Subject: Yapton Y/71/20/RES & Y/72/20/RES

Cc: Sam Pinkus [REDACTED]
Subject: RE: Yapton_Y/72/20/RES - 70 units

PLOTS
AS: 17 & 66
HANDED: -

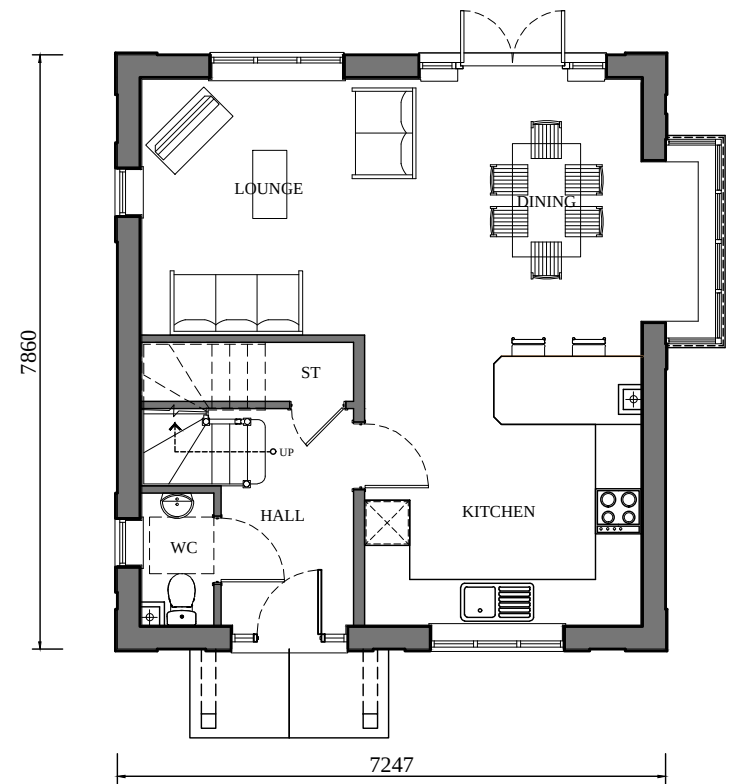
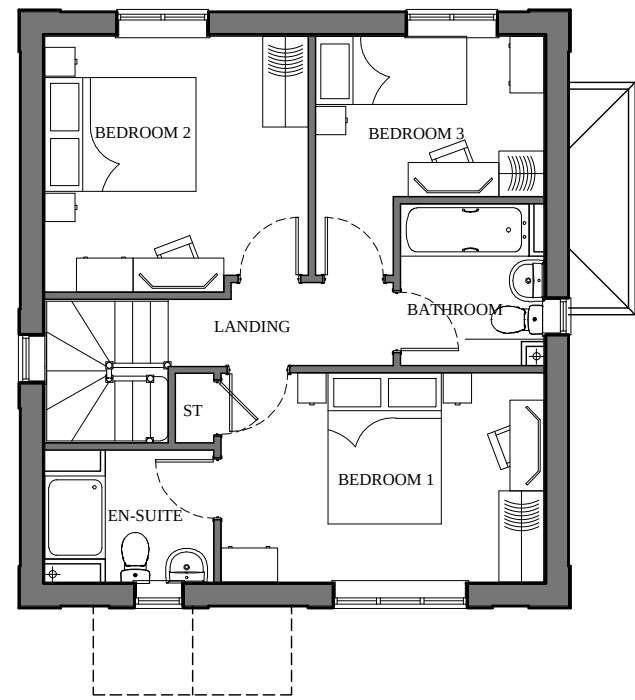
I have no objections in principle to the change to plot 17 although I think the existing arrangement offers a more visually interesting streetscene at the end of the cul-de-sac.

We're in the process of amending plans and particulars to account for the comments received, hope to have updates with you next week. Changes are limited with only one amendment which would impact the street scene. This is on the 38 unit scheme where Plot 17 has been amended. This had been a wide fronted dwelling as shown below though to account for amendments to the distribution of the affordable units the plot has been turned. Would you have any objections in principle to the change?
